EAST PYE SOLAR

WRITTEN REPRESENTATION

Planning Inspectorate Reference: EN0110014

Interested Party	Christopher Humphrey
Property	[REDACTED]
Relevant part of Scheme	Site 5 / proposed 400kV substation and associated infrastructure
Submission	Written Representation - Deadline 1
Interested Party reference	F83984C72

Sources: Esri, TomTom, Garmin, FAO, NOAA, USGS, © OpenStreetMap contributors, and the GIS User Community

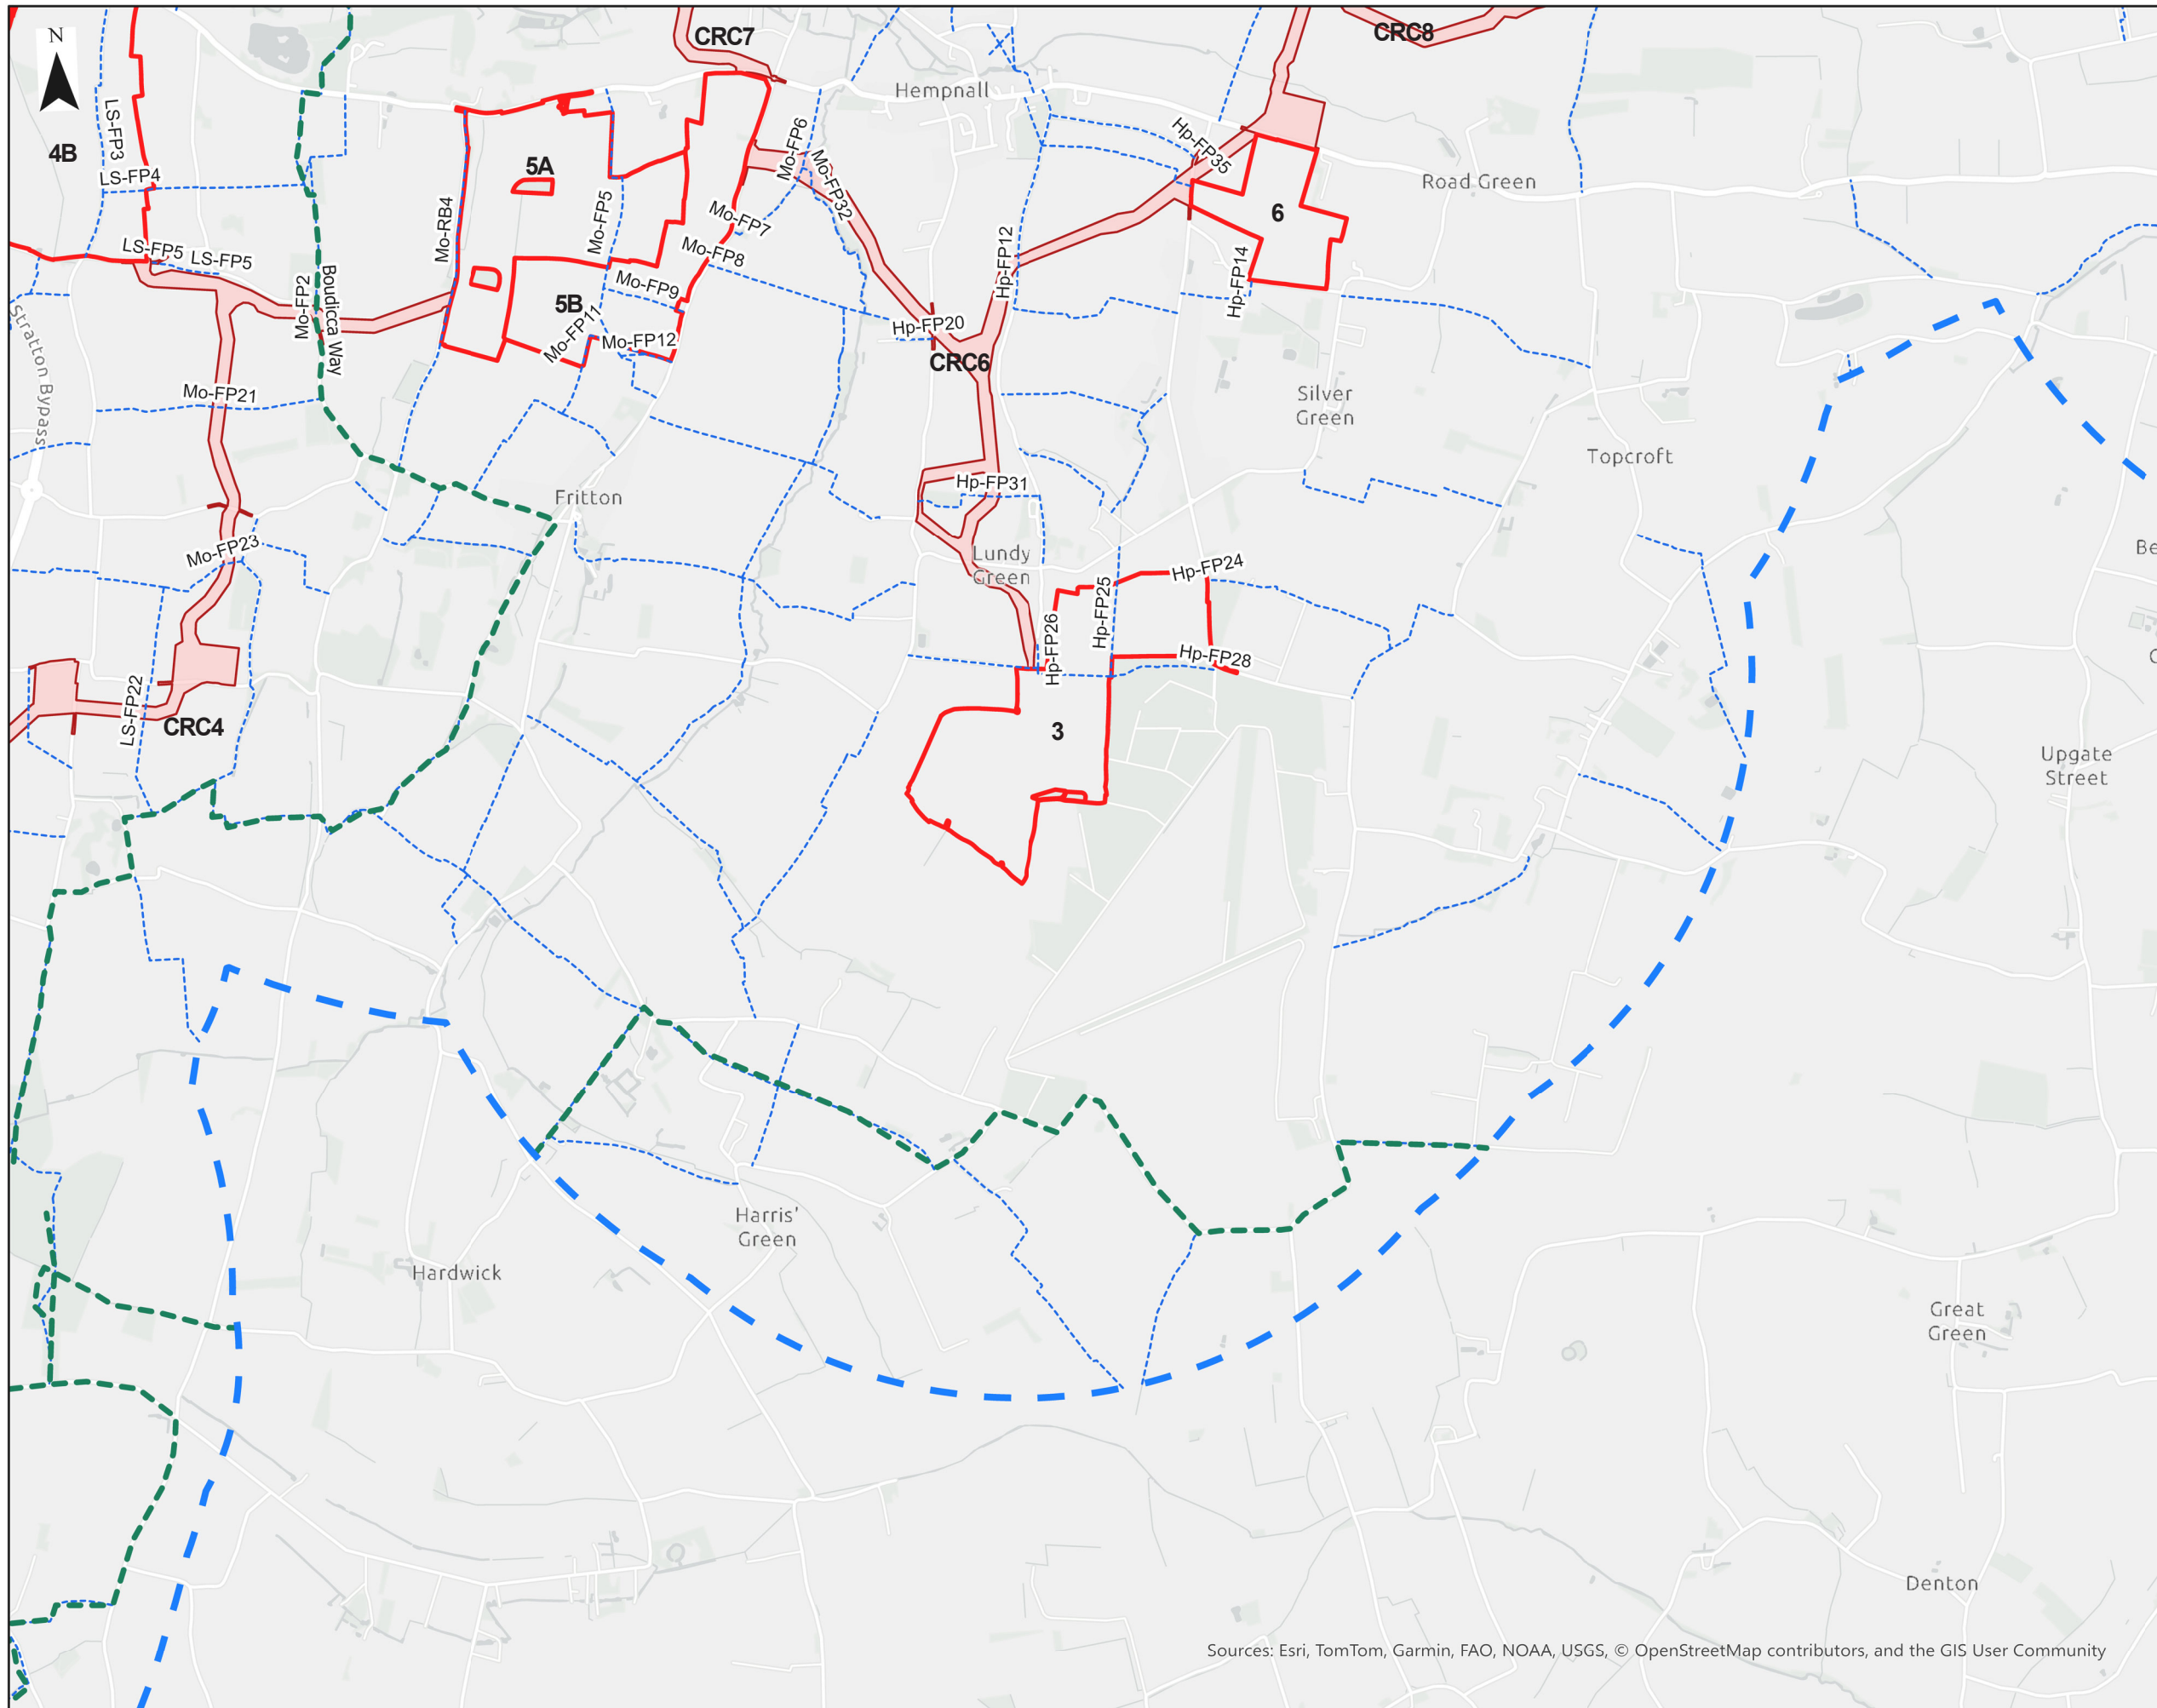
I therefore ask that the Applicant confirms how the effects on users of the relevant footpath have been assessed in the vicinity of [REDACTED] and the Site 5 Project Substation/access track, and how safe and convenient use of the route will be maintained during construction, operation, maintenance and periodic replacement activity. Particular attention should be given to locations where the operational track runs alongside or intersects the PRow.
